MIDTOWN COLLECTION AT HANNAH RIDGE FILING NO. 3

PUD DEVELOPMENT PLAN AND PRELIMINARY PLAN

PCDD FILE NO.: PUDSP-20-007

PUD DEVELOPMENT PLAN & PRELIMINARY PLAN
COVER SHEET

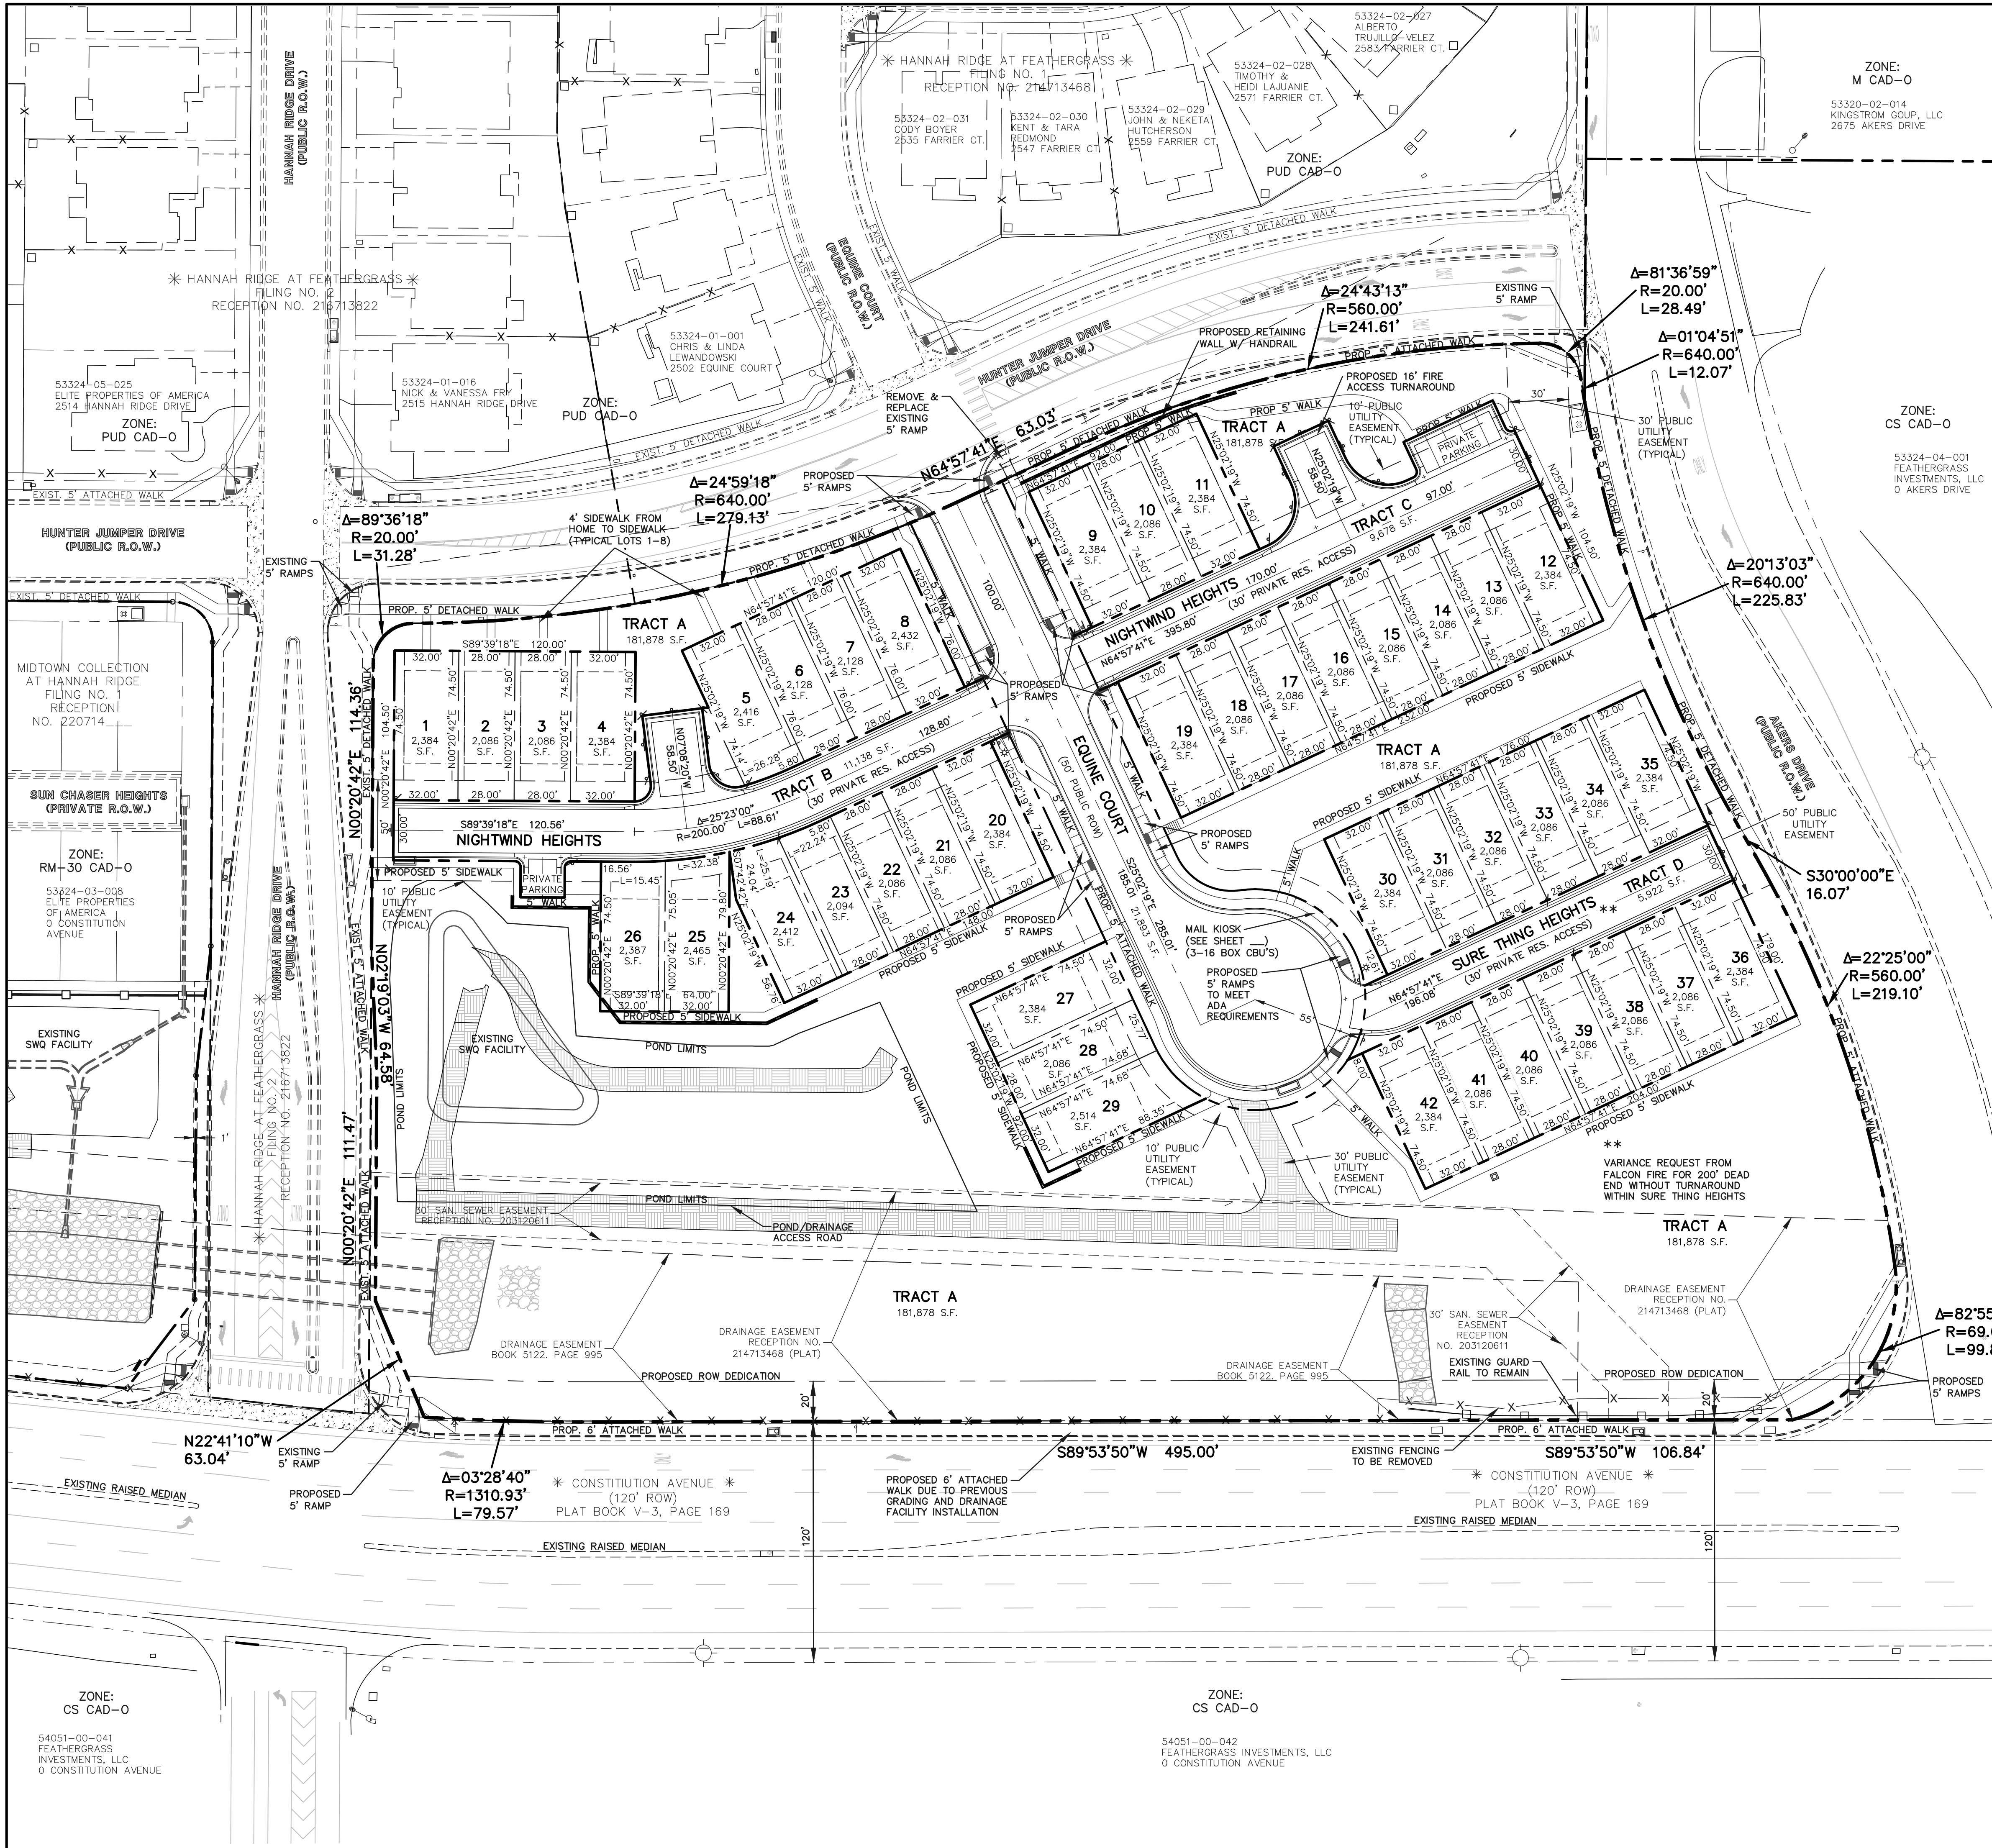
•Potentially Seasonally High Groundwater:(name lots or location of area) Placed in tracts and underdrains for mitigation?

9. SIGHT DISTANCE TRIANGLE EASEMENTS ARE IDENTIFIED ON THESE PLANS.
10. GEOLOGIC HAZARD NOTE: NO LOTS HAVE BEEN FOUND TO BE IMPACTED BY GEOLOGIC HAZARDS. NO MITIGATION MEASURES ARE REQUIRED AND A MAP OF THE AREA CAN BE FOUND IN THE REPORT "PRELIMINARY SUBSURFACE SOIL INVESTIGATION MIDTOWN AT HANNAH RIDGE TRACTS CC EL PASO COUNTY, COLORADO" PREPARED BY ENTECH ENGINEERING, INC. AVAILABLE AT THE EL PASO COUNTY PLANNING AND COMMUNITY DEVELOPMENT DEPARTMENT. show on plan

Verify that the site design complies with current Americans with Disabilities Act (ADA) laws and accessibility standards and has laid out the plan and associated grading and construction plans so that all site elements meet the applicable ADA design standards as published by the United States Department of Justice. Add this note: Approval of this plan and associated construction documents by El Paso County does not assure compliance with the ADA or any regulations or guidelines enacted or promulgated under or with respect to such laws. It is the responsibility of the developer/home builder to ensure ADA accessibility during construction of the public and private sidewalks.

Add this note and the note below:
Snow storage shall be accommodated onsite in available tracts and at ends of the private drive aisles, not in the public right-of-way.

BoCC Signature needed as well

MIDTOWN COLLECTION AT HANNAH RIDGE
FILING NO. 3
PUD DEVELOPMENT PLAN
PRELIMINARY PLAN

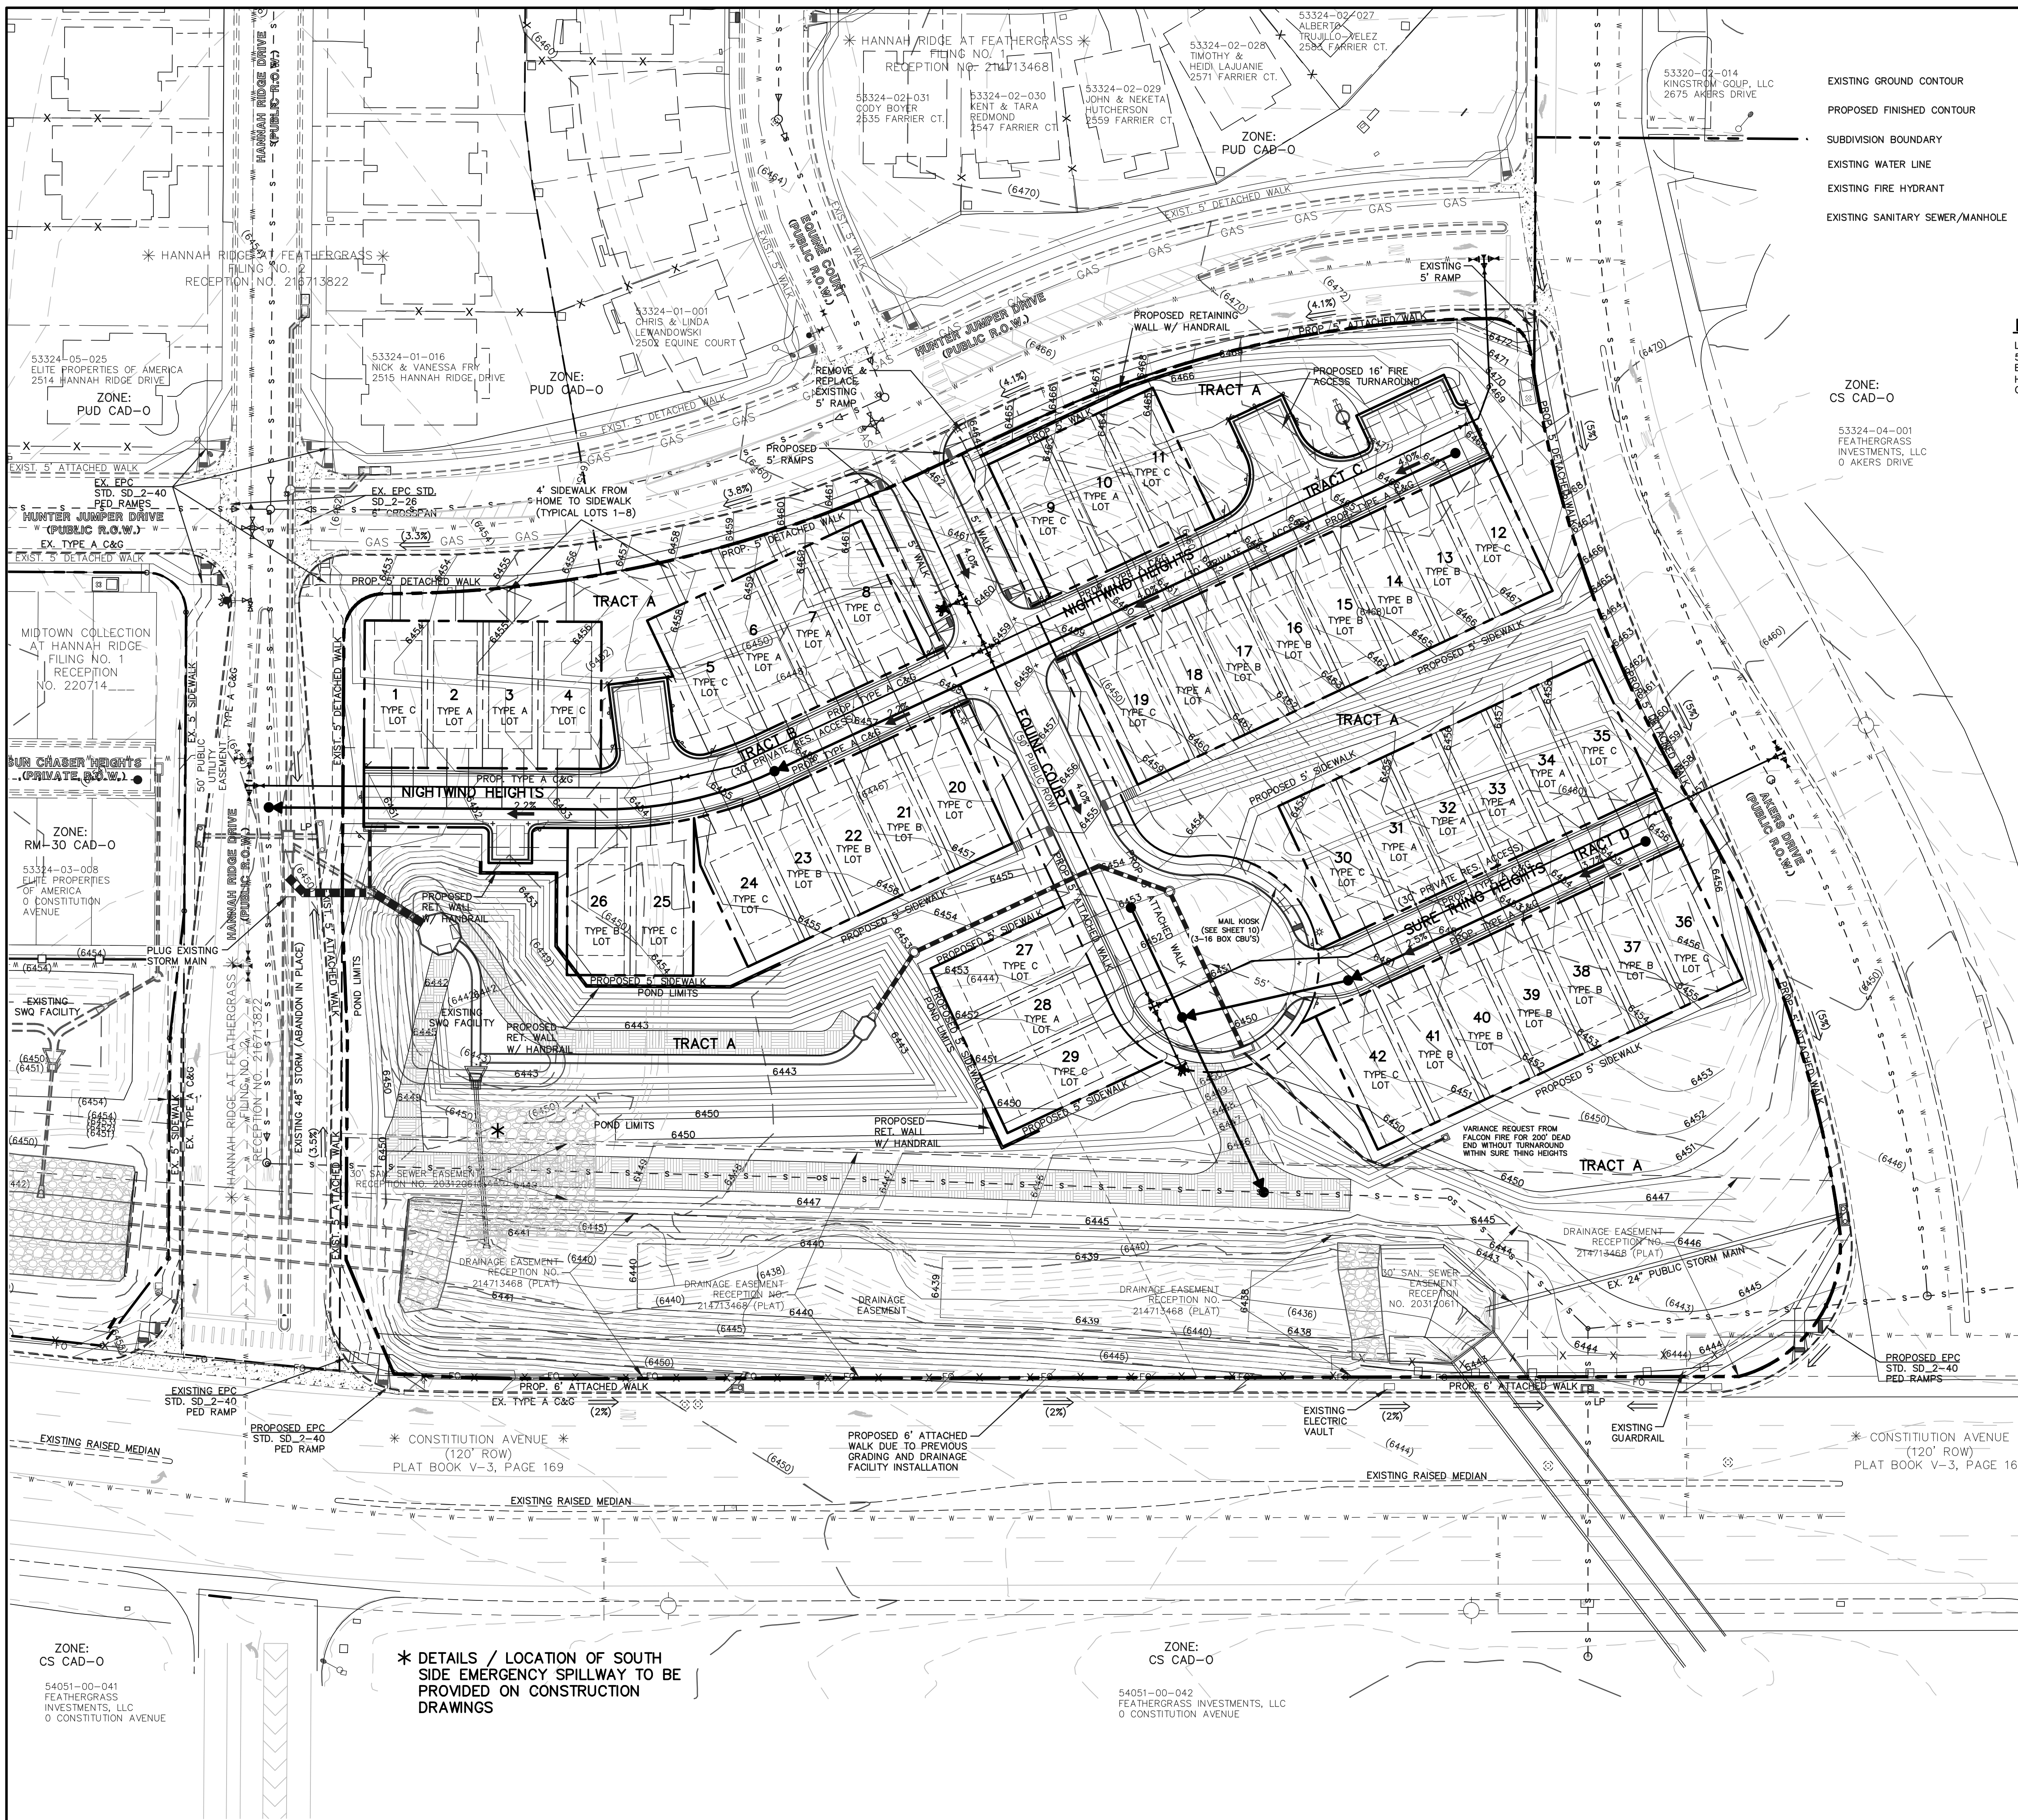
Please provide additional information regarding if this was approved or is pending. If pending, this should be resolved prior to hearing
